Recommendation Report for Planning Permission for Works or Extension to a Dwelling

REF NO: P/86/22/HH

LOCATION: Rose Cottage
Priors Way
Pagham
PO21 3JU

PROPOSAL: Single storey front extension, following demolition of existing swimming pool.

PROPOSED ELEVATIONS

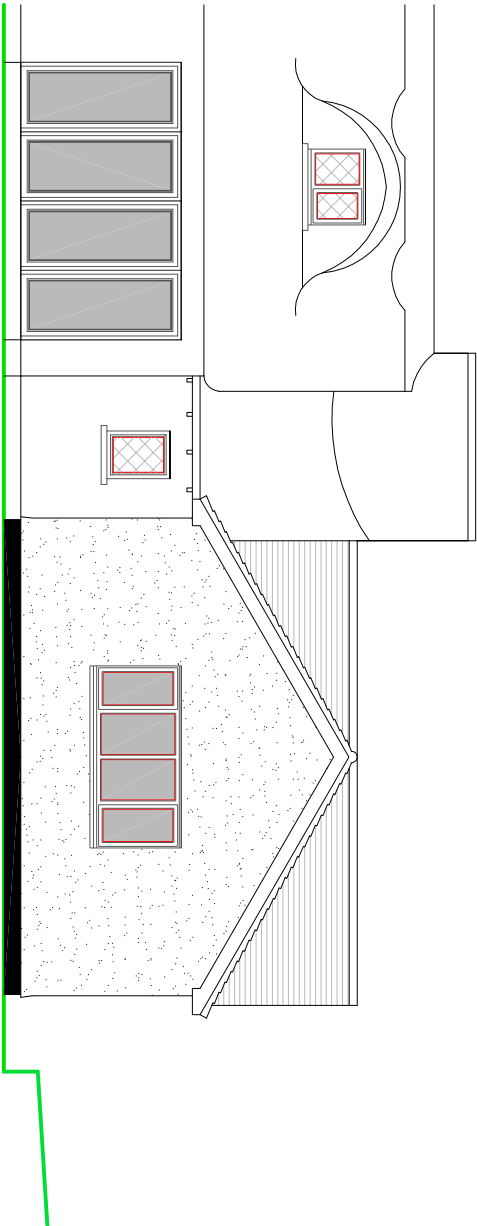
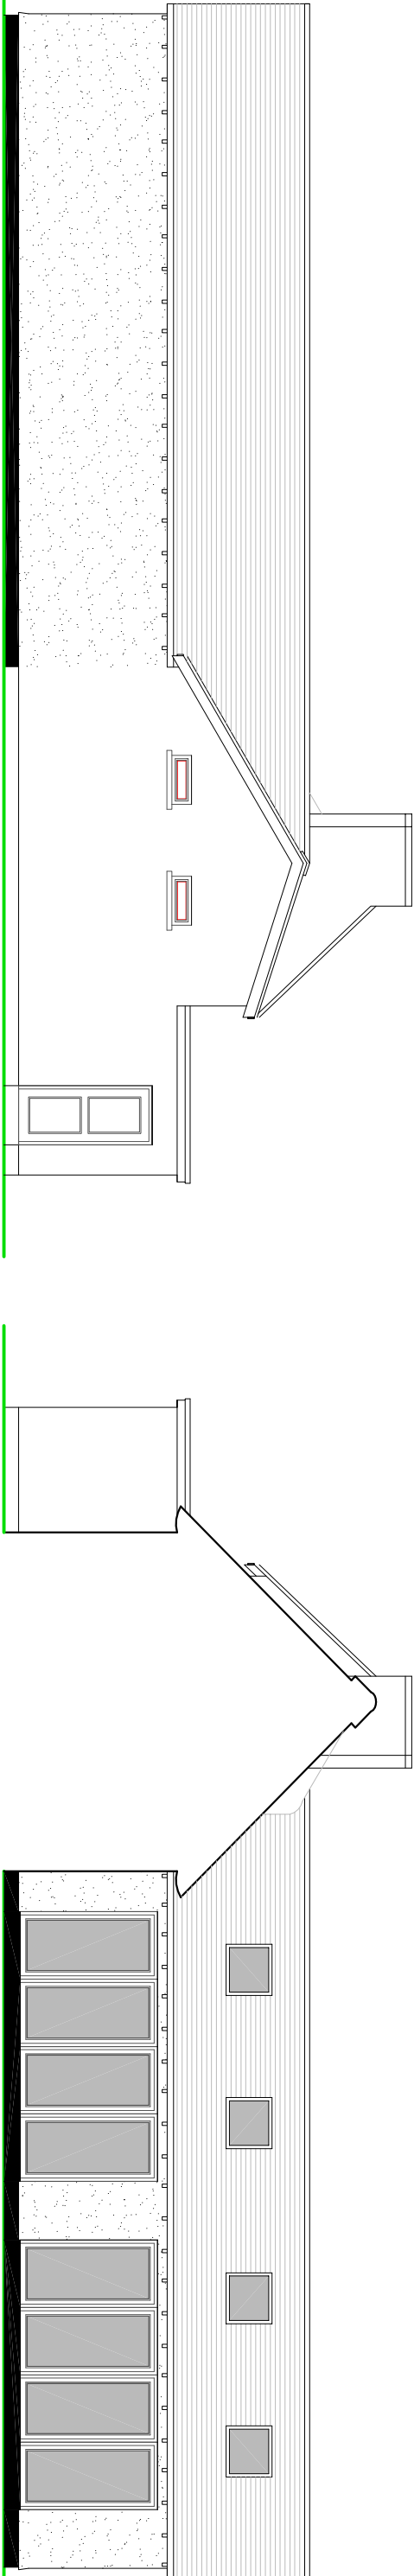
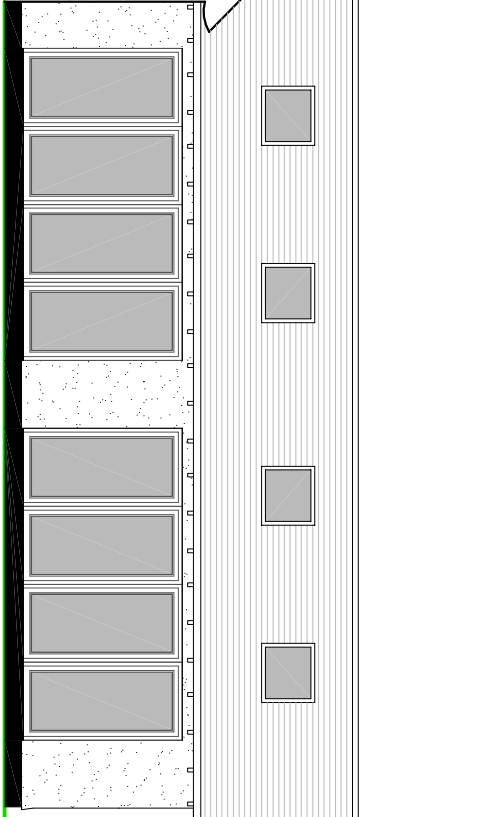
- What is the planned ridge height for the extension?

The proposal will be single storey and have a gable roof measuring approximately 4.7m high and 2.65m at the eaves. This roof will feature four rooflights facing northwest, which will sit flush to the roof and have no impact on residential privacy. The proposal will retain a minimum of 1.75m to the southeast boundary, 10.97m to the southwest, and 24m to the northwest. These distances are acceptable, and in accord with D DM4 of the Arun Local Plan. There will be little overbearing or overshadowing of neighbouring

In addition to the rooflights, the proposal will feature new folding doors and a window to the southwest (front) elevation, and two sets of folding doors to the northwest elevation. None of these features will unduly overlook any neighbouring properties, instead facing the front garden, and as such pose no risk of adverse harm to residential privacy or amenity.

EXISTING GROUND FLOOR PLAN

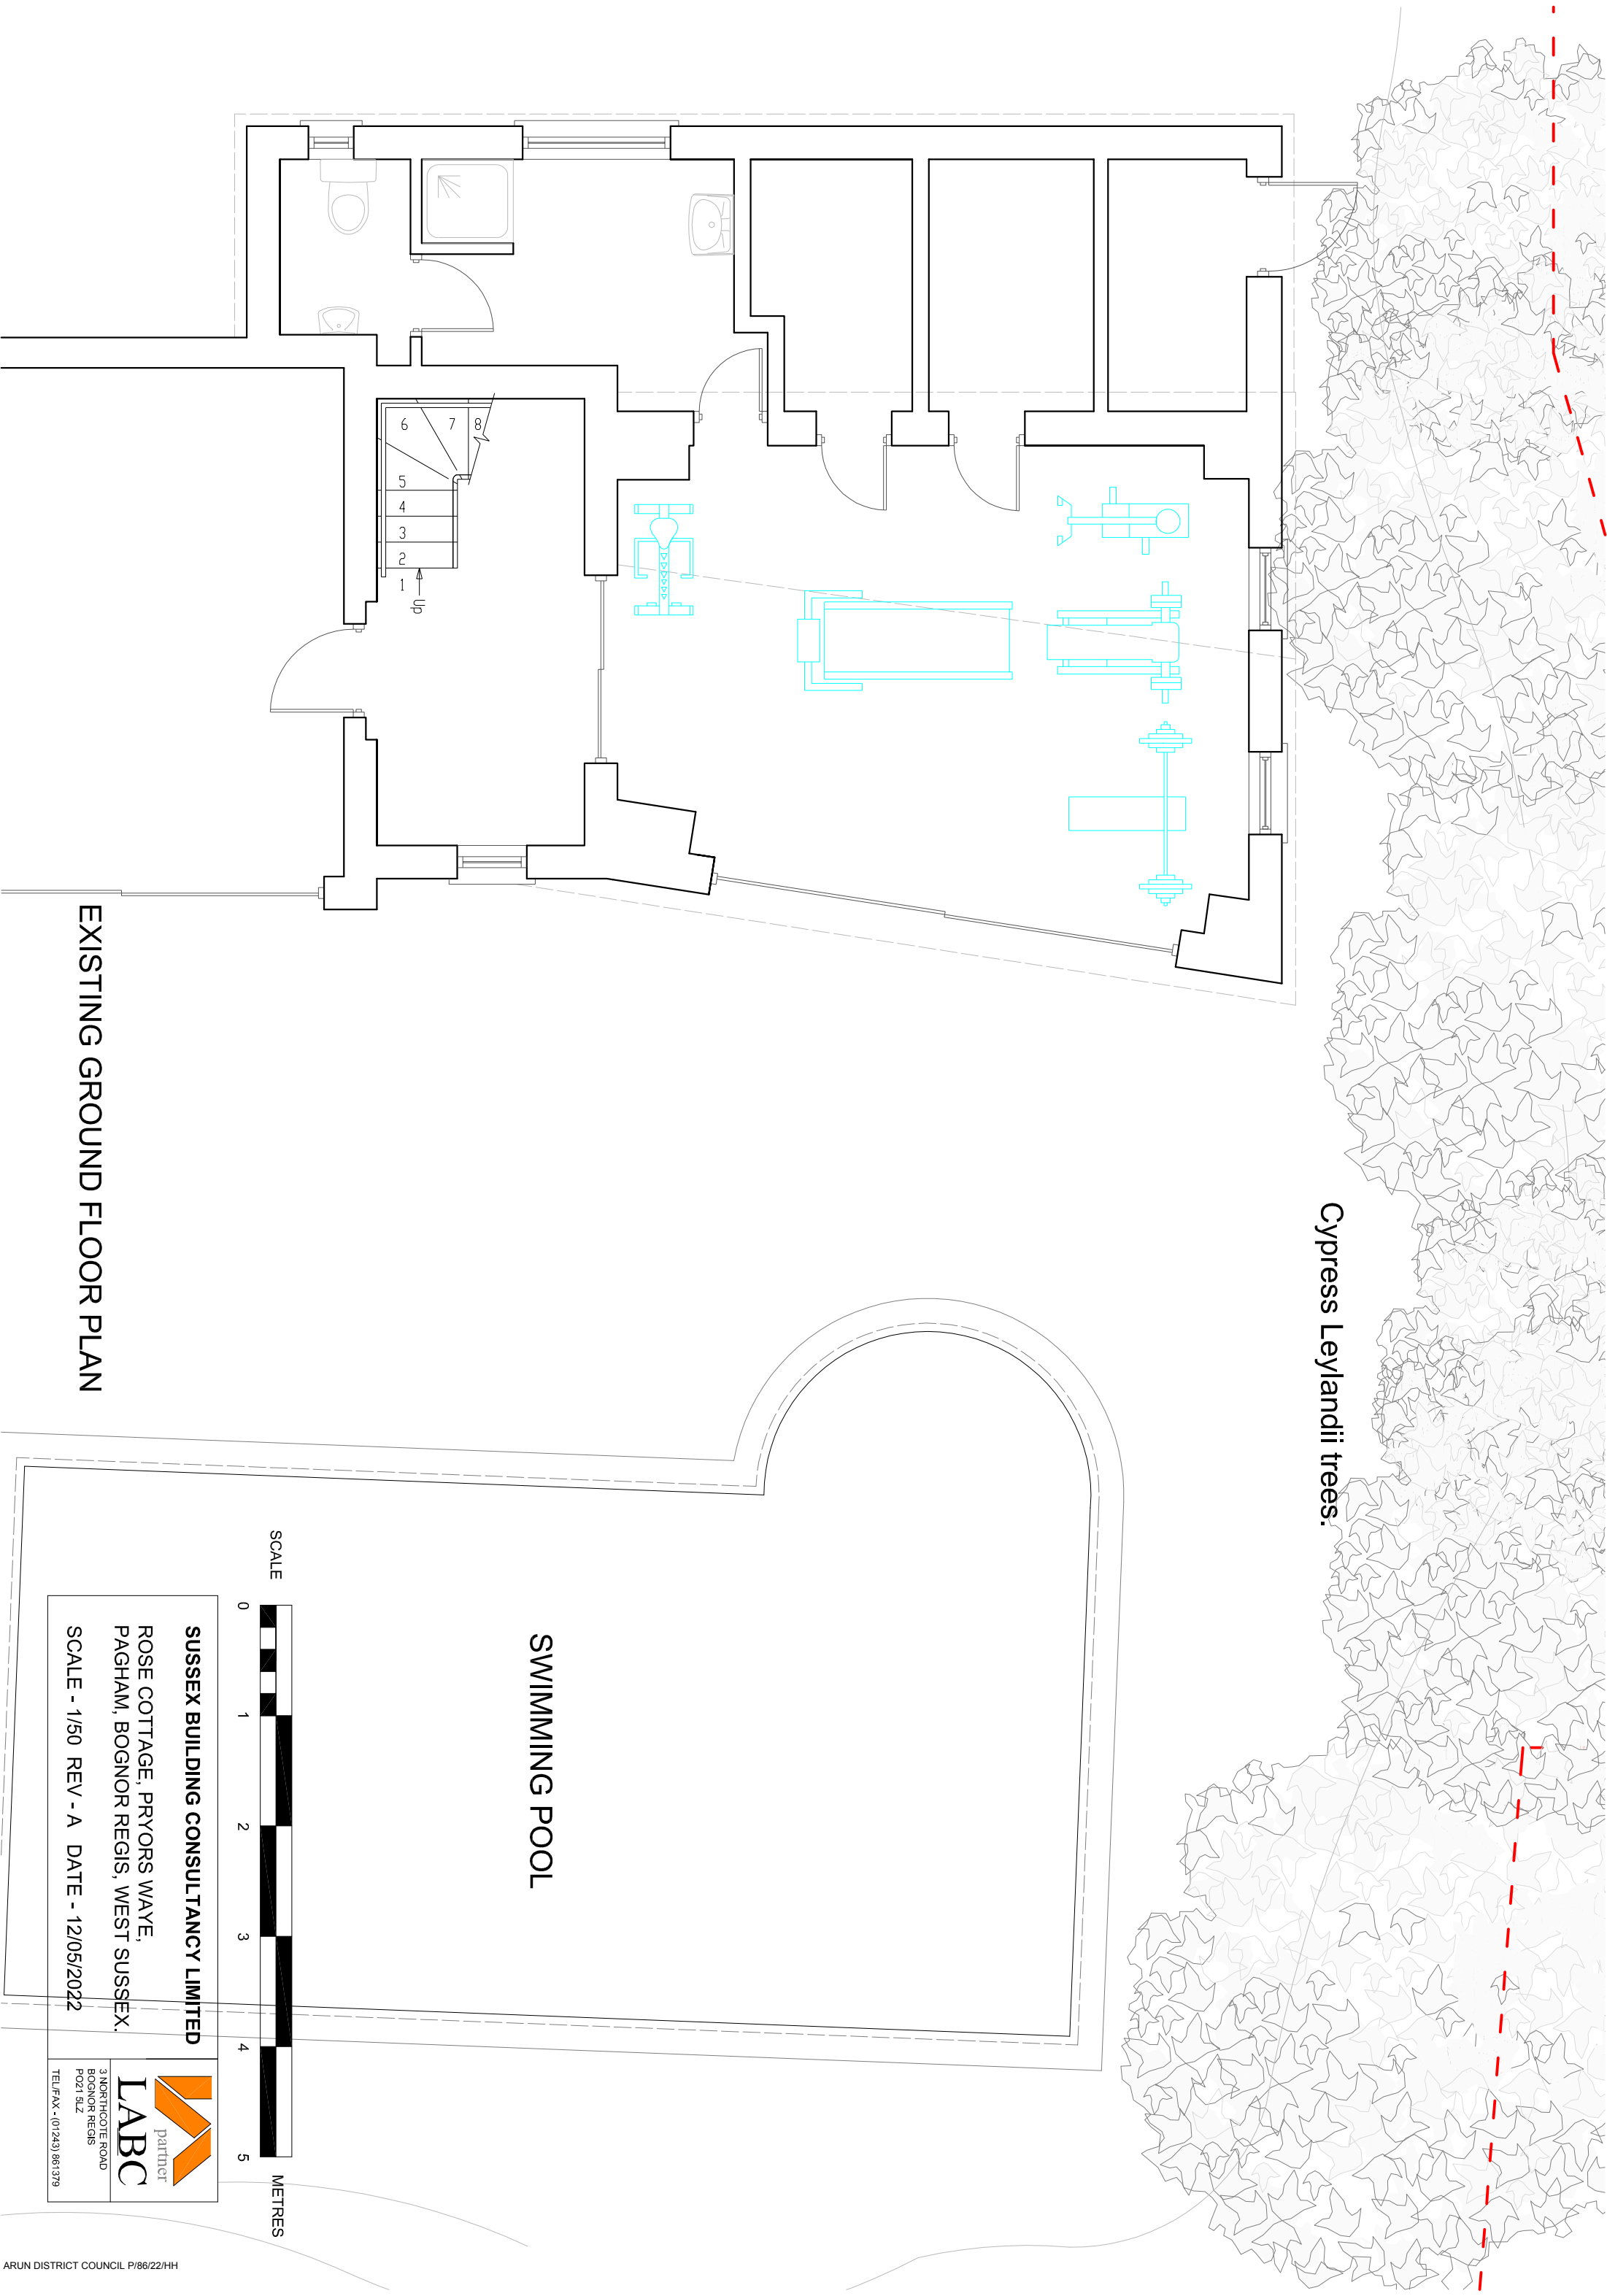
The proposed development will include the removal of a number of leylandii trees along the southeast boundary, none of which are protected by a Tree Preservation Order. This is acceptable and will have a beneficial impact on the neighbouring properties to the southeast by increasing the amount of light entering their gardens.

PROPOSED GROUND FLOOR PLAN

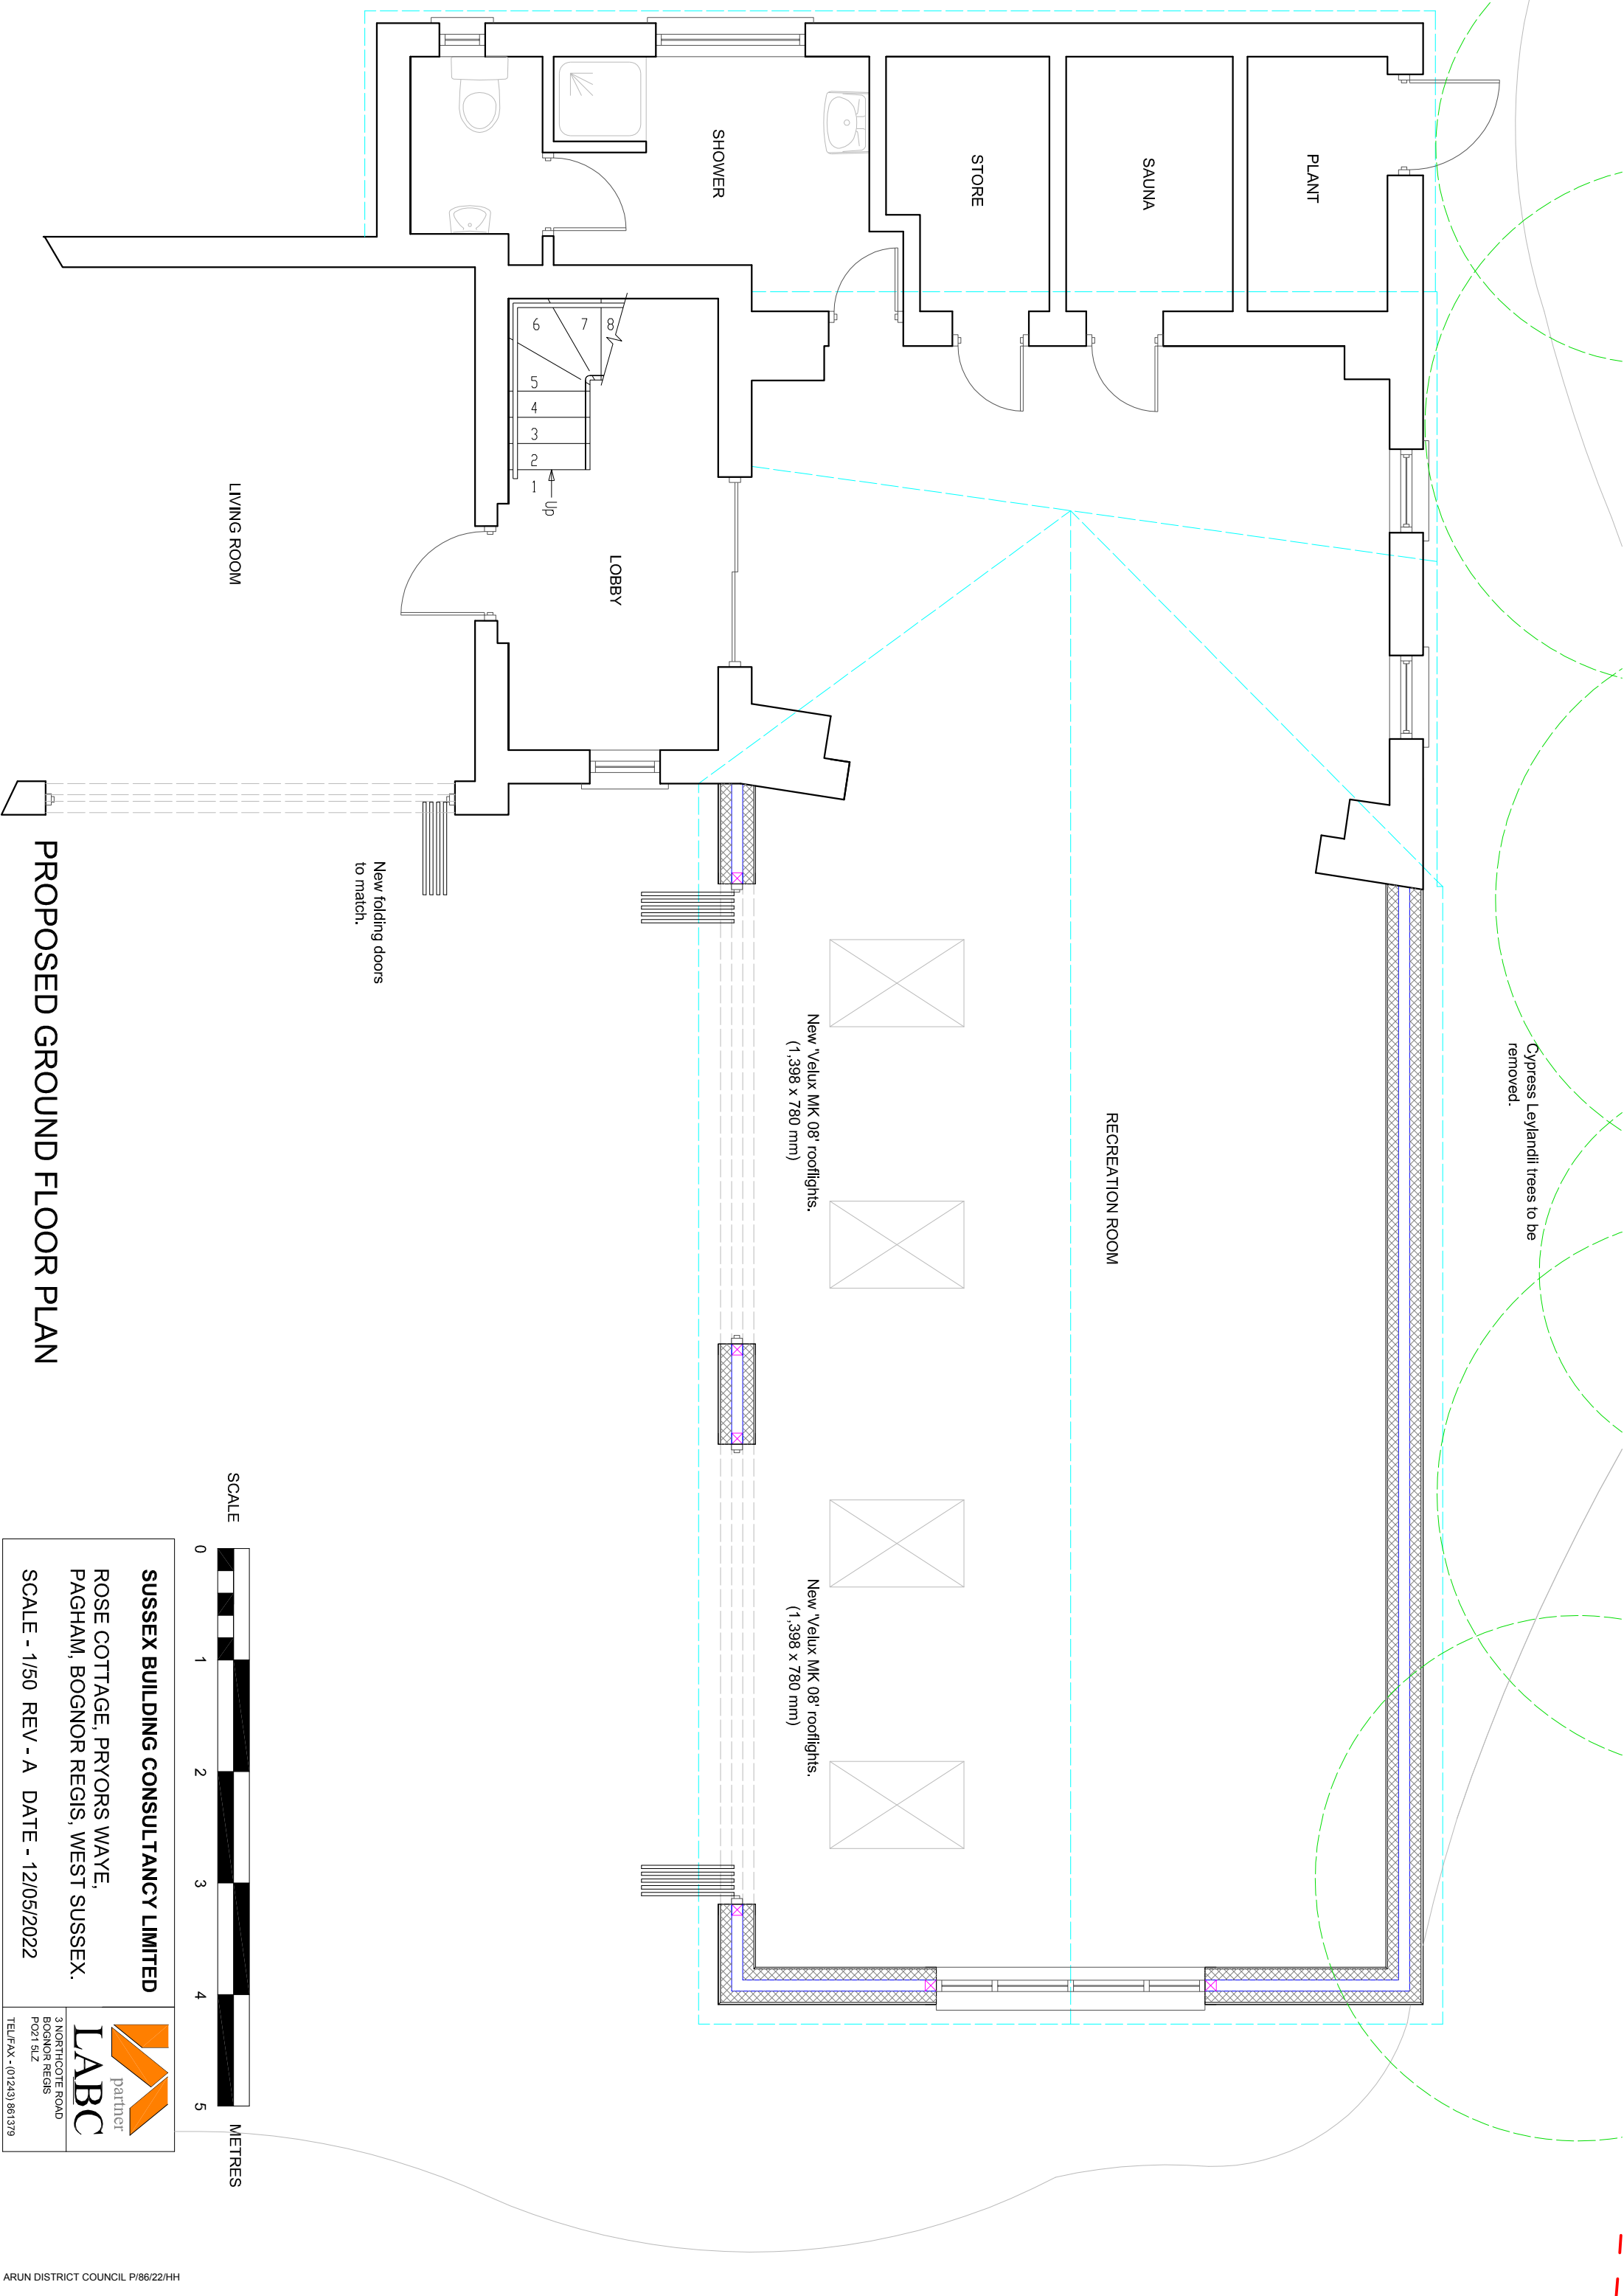
- Sunlight is already minimal due to the tall trees on the boundary.
- Concern over the proximity of the proposed building to their boundary.
- The boundary lines shown on the proposed plans does not match the boundary lines shown on their title deeds.

- Will there be unreasonable noise arising from the Plant Room shown on the plans?
- What distance will exist between the rear of the extension and the boundary fences? The plans show a measurement of 1.75m which appears to taper, but also state that the distances will be established at time of build.

Concern has been raised regarding potential overshadowing and impact on light that there may be on neighbouring properties to the southeast. At present, there are a row of tall leylandii which site on the boundary with these neighbouring properties and cause an issue with blocking out light which comes into their gardens. The proposal will not increase issues regarding lack of light, as it will include the removal of these leylandii, instead resulting in an improvement in the amount of light received in the gardens. Given the height of the proposal in comparison to these trees, the overshadowing impact that the proposal may have will be minimal and will not result in adverse blocking of light in the neighbouring gardens. Concern was raised over noise levels from the proposed plant room. Being an internal room, the resulting noise levels will be minimal, and not unduly harmful to neighbouring amenity.
